From: Sue Howell <Sue.Howell@arun.gov.uk>
Sent: 09 October 2019 17:34
To: Planning.Responses <Planning.Responses@arun.gov.uk>
Cc: Michael Eastham <Michael.Eastham@arun.gov.uk>
Subject: RE: Planning Consultation on WA/95/19/DOC

Comment from Greenspace

APPLICATION NO: WA/95/19/DOC

Site Address: Land East of Tye Lane Walberton

Project	Land East of Tye Lane, Walberton		
Title	Golf Course Netting Indicative Detail		
Client	Linden Homes		
Scale	1:100 @ A3	Drawn	AL
Date	Sept 2019	Checked	GC
Drawing No.	CSA/3823/119	Rev	B

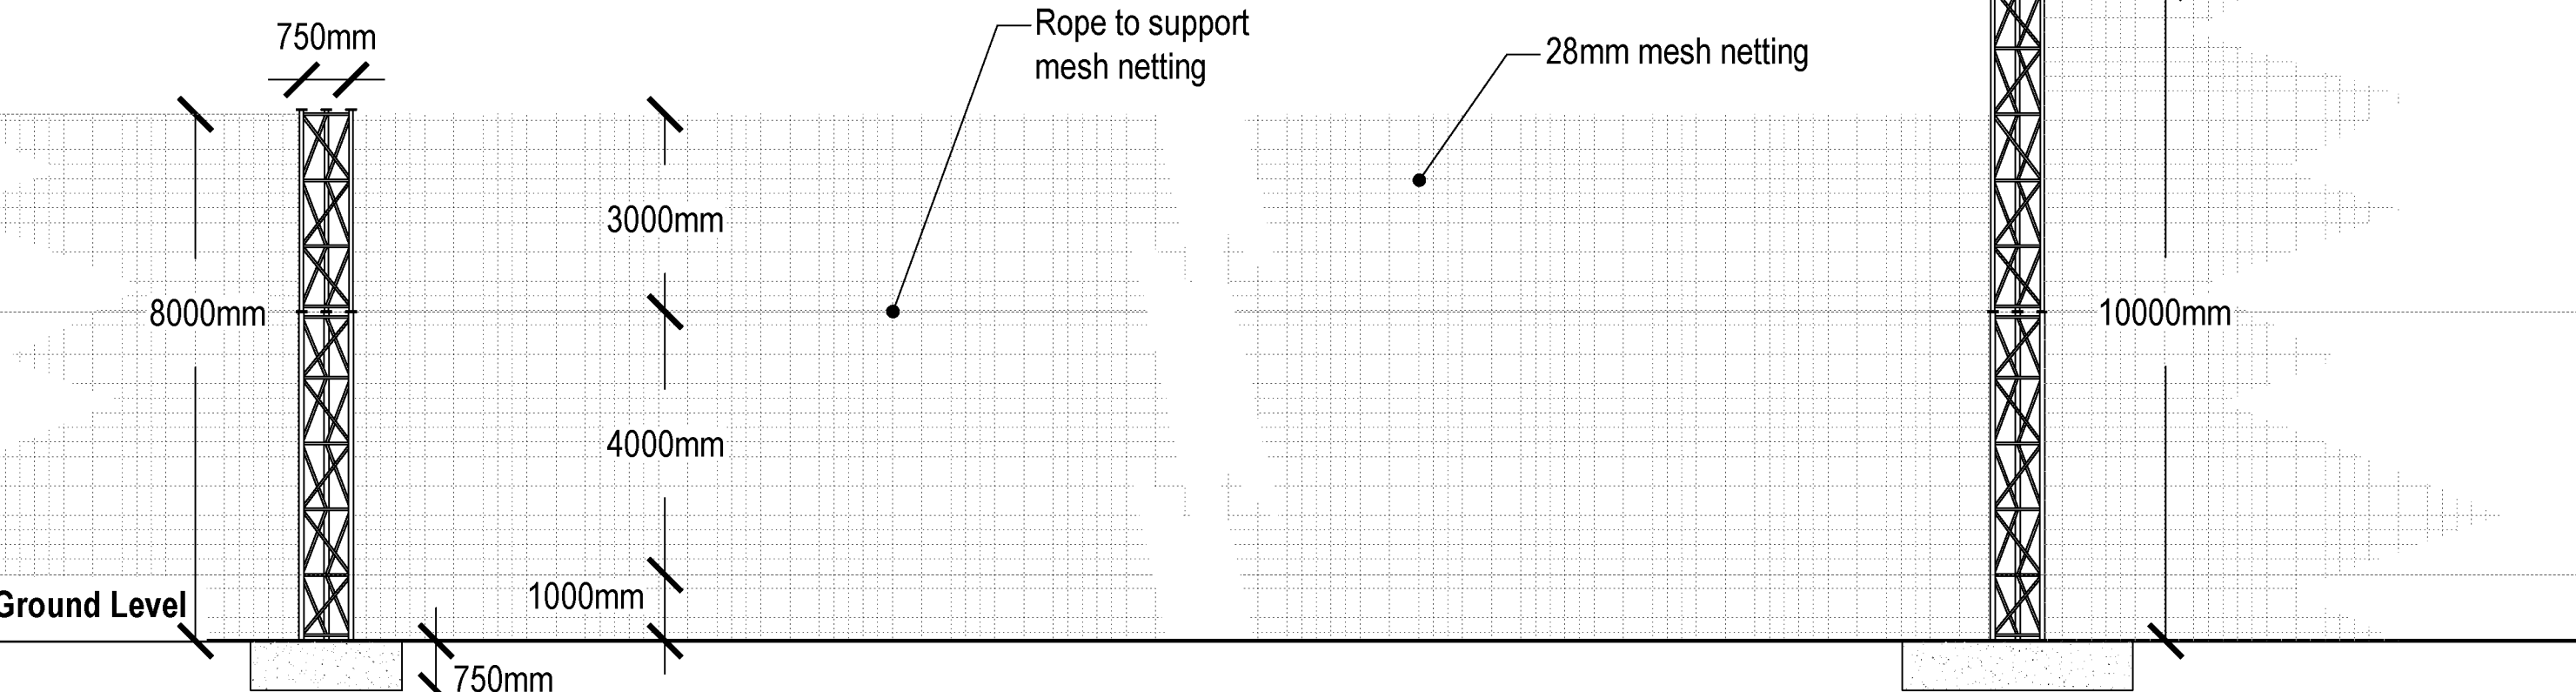
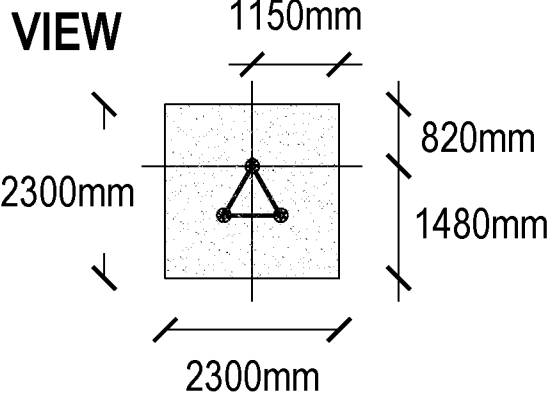
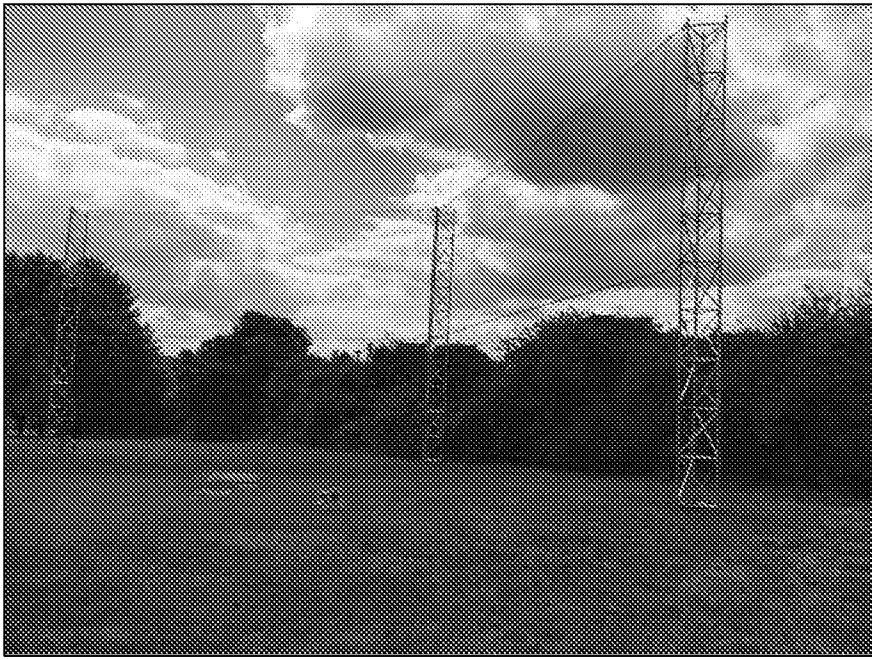
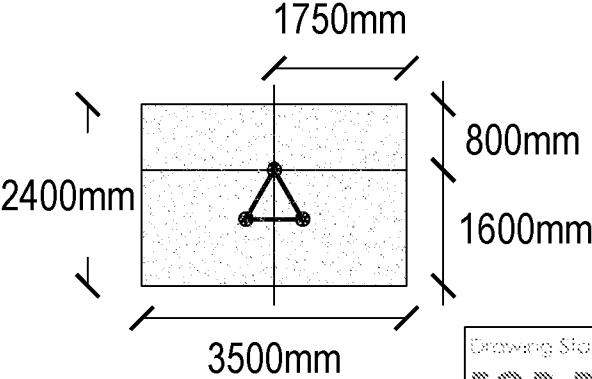
The detail of the ball stop netting adjacent to the golf course, has a planting proposal which whilst would not disguise it, will go somewhere over time to softening the impact of this – however not to the full height 10m of the fencing proposed. The visual impact of these measures along this boundary and particularly to plot 138 should be noted. There has been the inclusion of mature tree planting in this location which has a greater opportunity as it establishes to detract the eye, whilst allowing important views through to the golf course beyond.

The fencing will need to be maintained in good condition thereafter in order for the purpose of this to be realised.
